CITY OF ALBUQUERQUE

December 27, 2023

**RE: MDS - Montage Subdivision Unit 7 on Bobby Foster
Grading and Drainage Submittal for Preliminary Plat and Grading Permit
Grading Plan Engineer's Stamp Date: 8/16/2023
Hydrology File: R16D100A**

Pldiet: 1/19/2023 5:20:47 PM, By:Trujillo, Corie
Project: 230155001 - Montage Unit 7 - Mesa del Sol/05 Design/05.13 Drainage/Hydrology/2_MDS MONTAGE 7
BASINS
Last Saved: 1/19/2023 5:16:42 PM, crrujillo

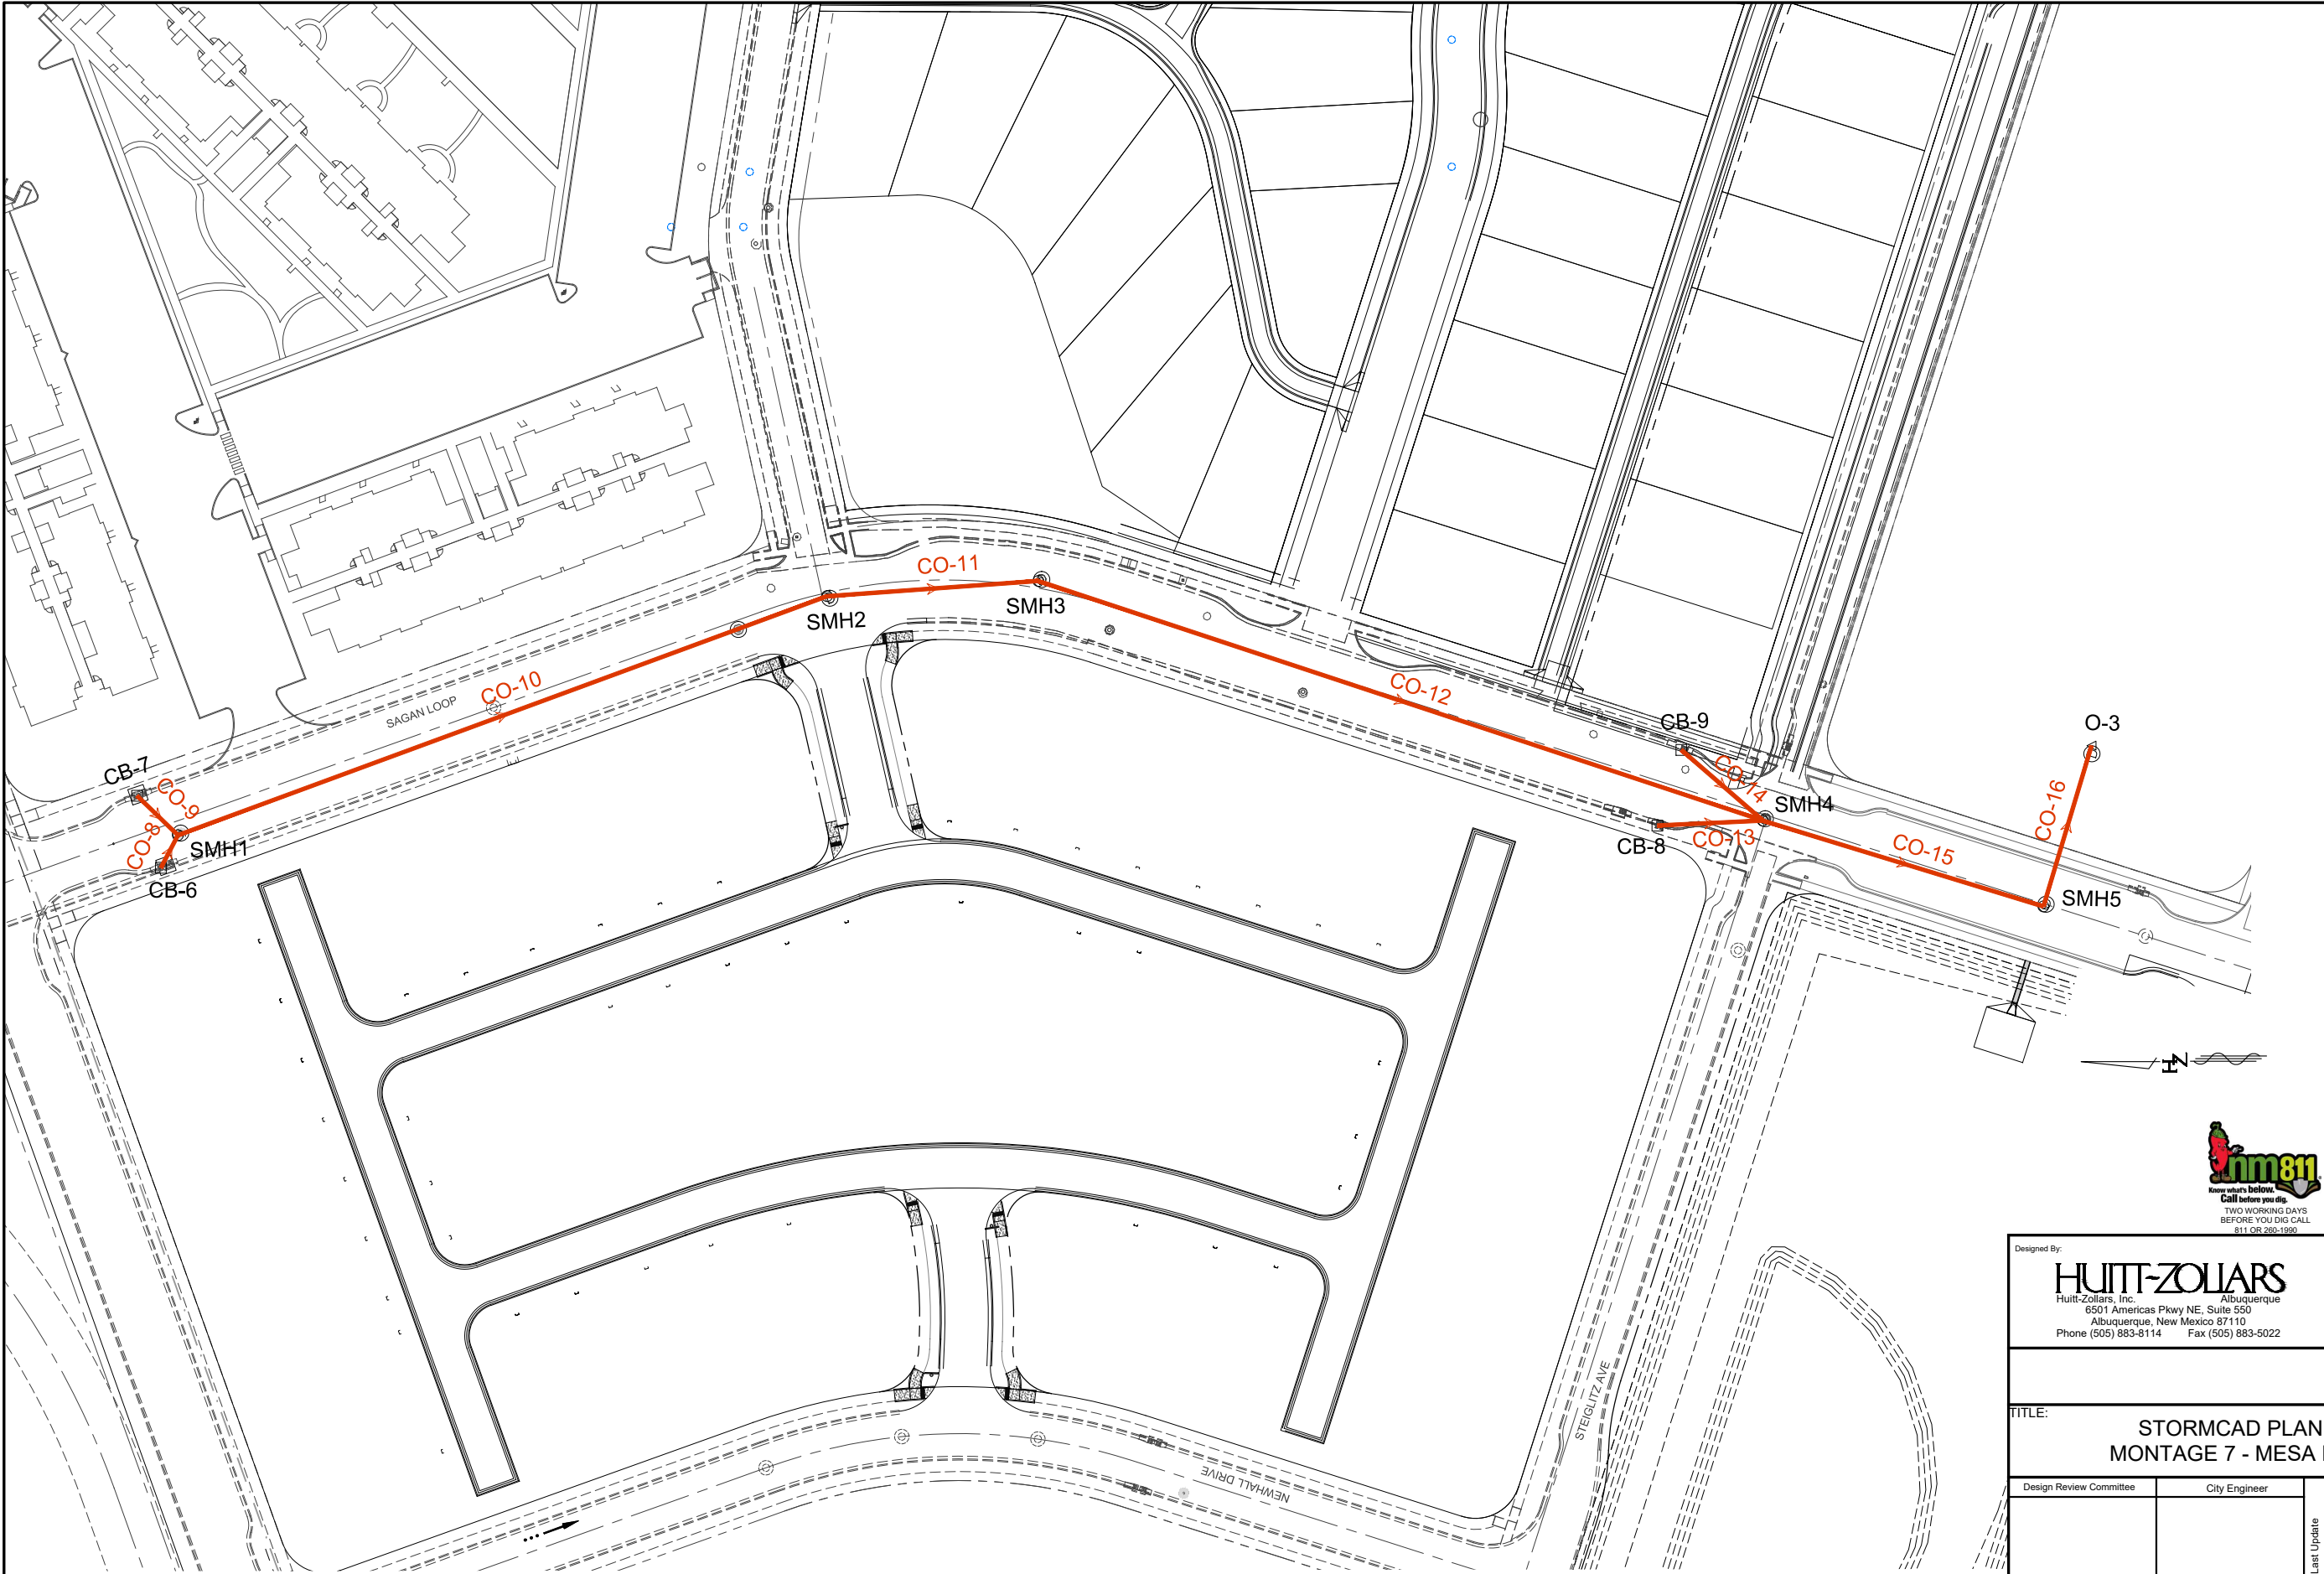
1. Please provide sub-basin map. I do need this map with basins' acreages to verify your calculations.

TITLE: GRADING COMPOSITE

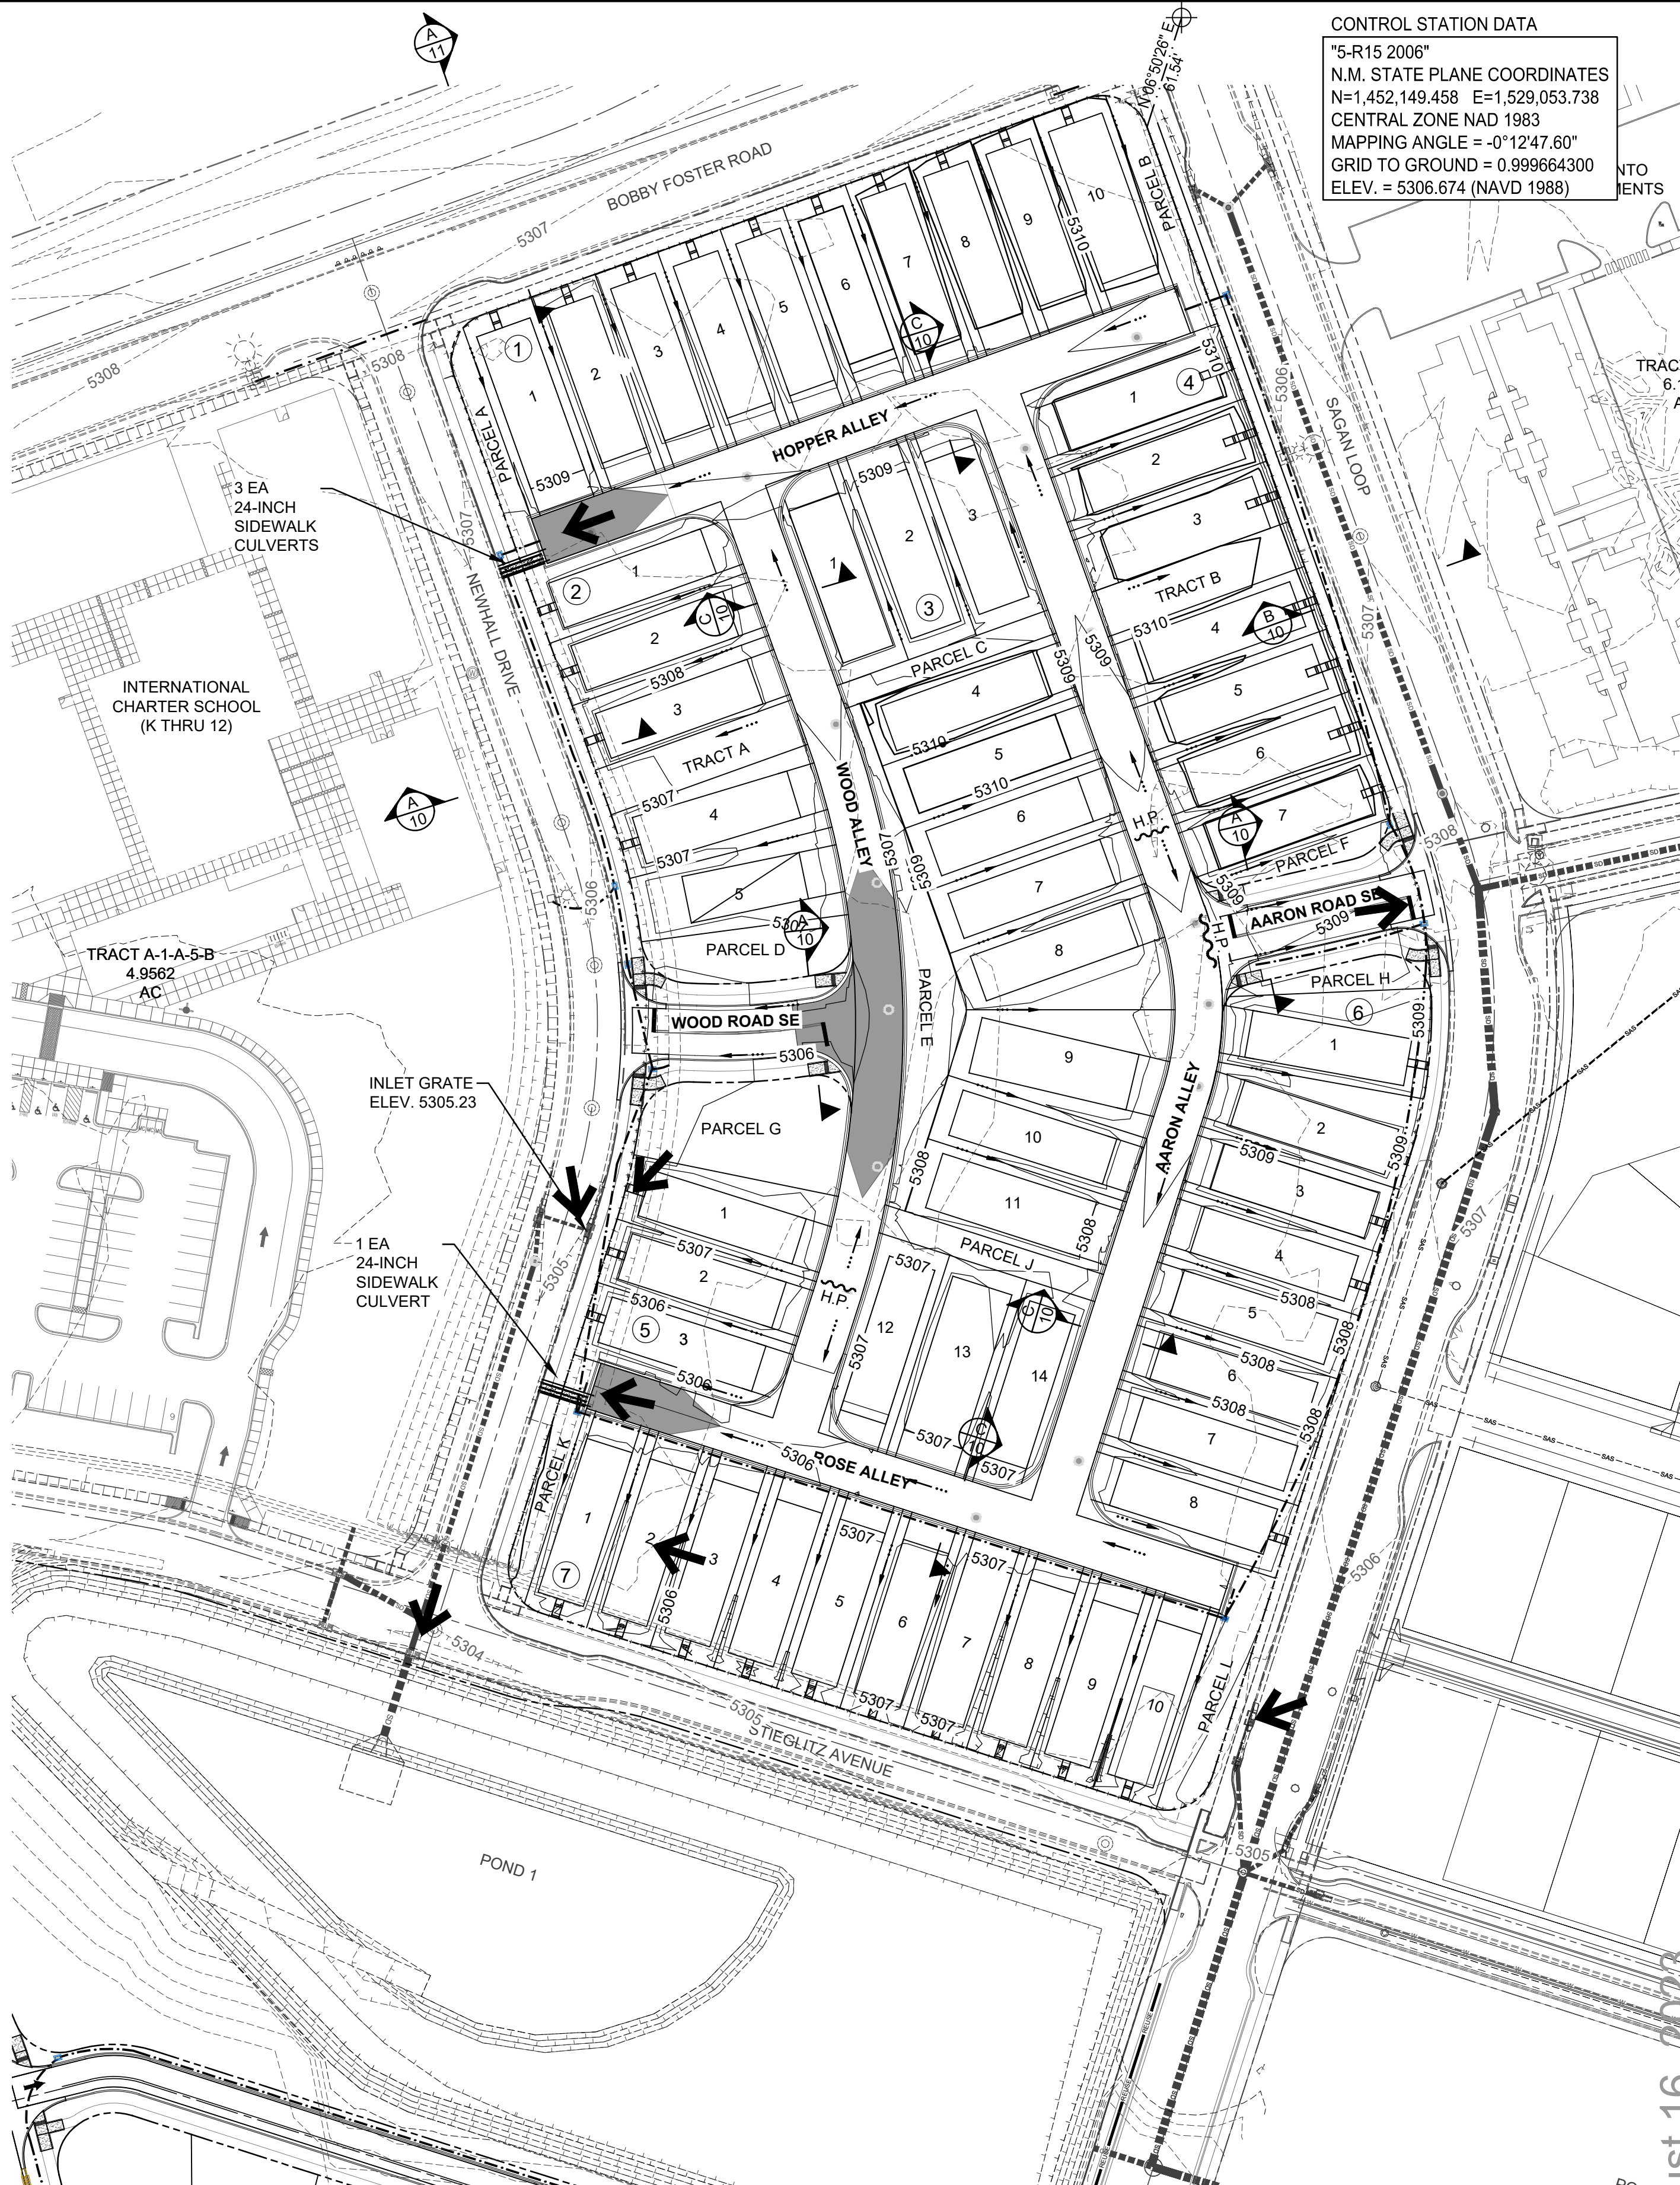
4. Change the “,” to “.” in the area of disturbance to 7.5 on sheet 1.
AREA OF DISTURBANCE IS APPROXIMATELY 7,5
